Central Place Sydney project office
63 Kensington Street, Chippendale 2008

4 October 2022

Re: Toga State Significant Development SSD 33258337

I write representing Dexus CPA Pty Ltd (Dexus) and Henry Deane Building Nominees Pty Ltd & Gateway Building Nominees Pty Ltd (Frasers Property Australia), known as 'The Consortium', to provide this letter of in-principle support in response to the Toga Central State Significant Development 33258337 (SSD 33258337).

Landscape Masterplan Ground Level

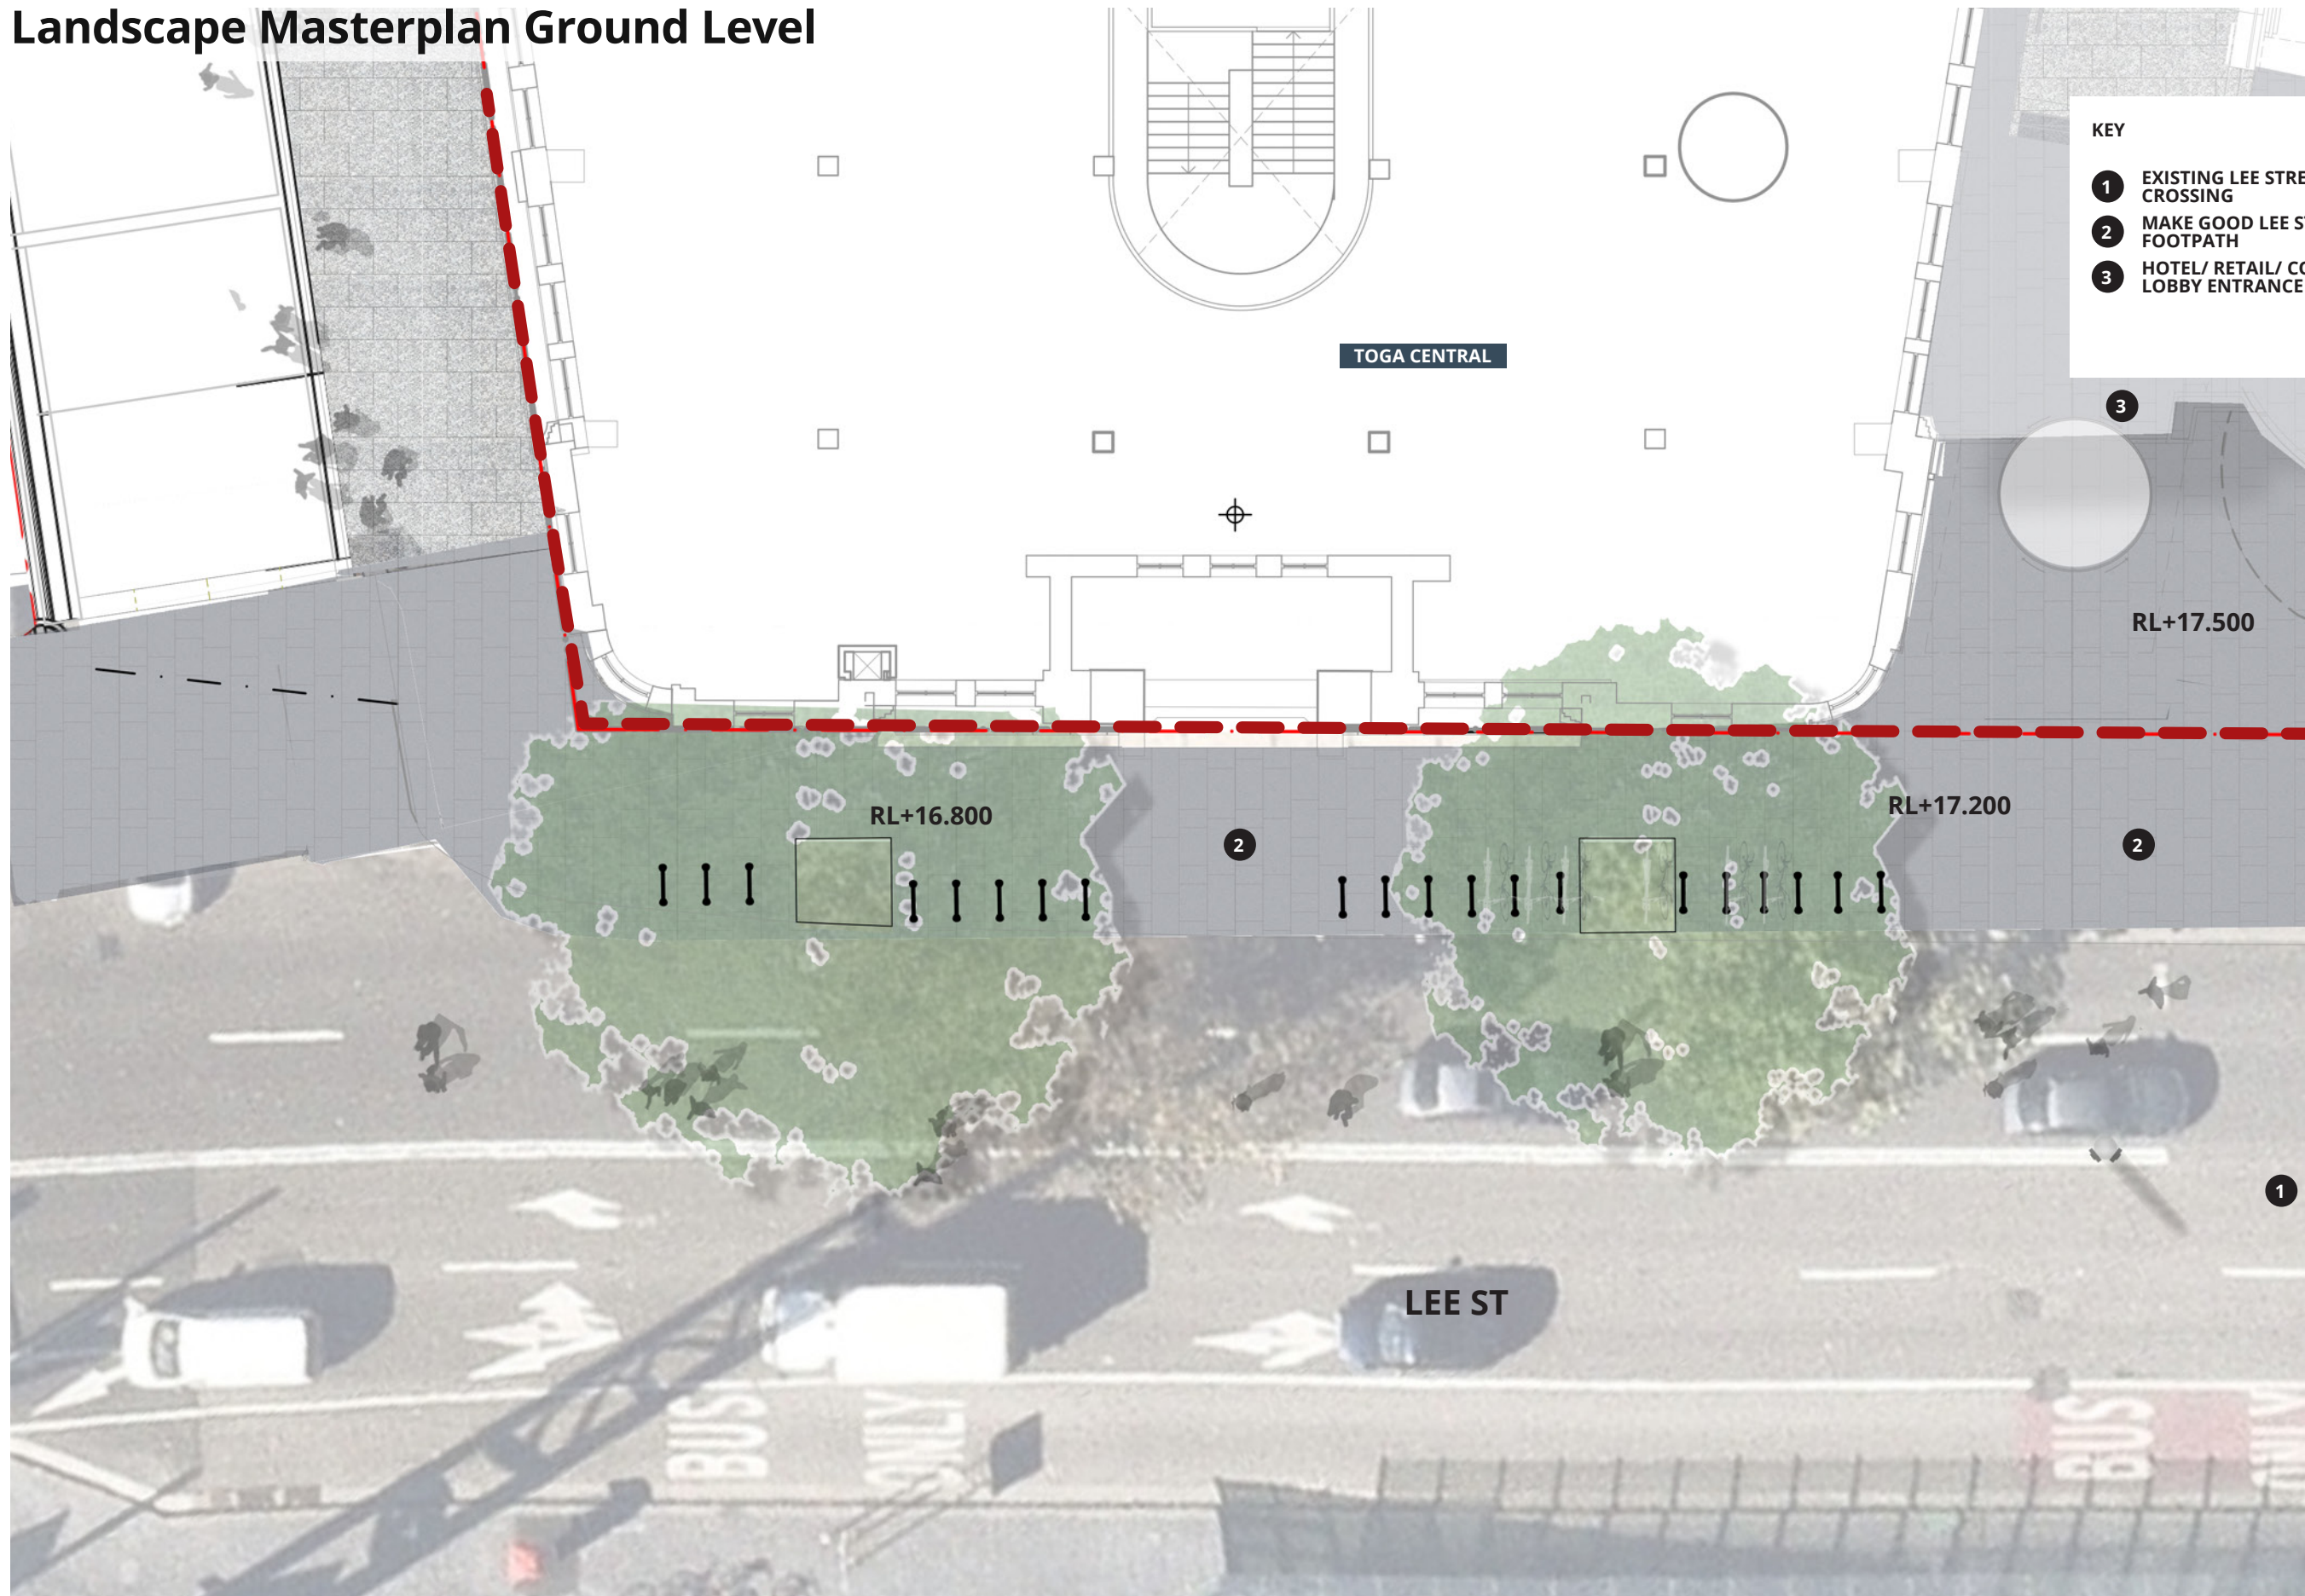
The Landscape and Public Domain Report ("Public Domain Report") prepared by Arcadia has made assumptions in regard to the public realm in areas outside of the Toga lot boundary, particularly as it relates to Upper Ground level. The DPE should be made aware that whilst this design is located on the Consortium's land, it is not supported by the Consortium. However, the Consortium is working closely with Toga and the City of Sydney Council to agree the best urban outcome for the plaza and public domain areas across the various landholdings and has confidence that a successful outcome can be reached.

We acknowledge that the best outcome is not defined by lot boundaries, however, highlight that consideration must be given to the volumes of pedestrian movements entering and exiting Central Station which is one of the busiest railway stations in Australia. Furthermore, the staging of the three Western Gateway Sub-precinct developments needs to be taken into account, to ensure adequate pedestrian access is provided as each development is completed.
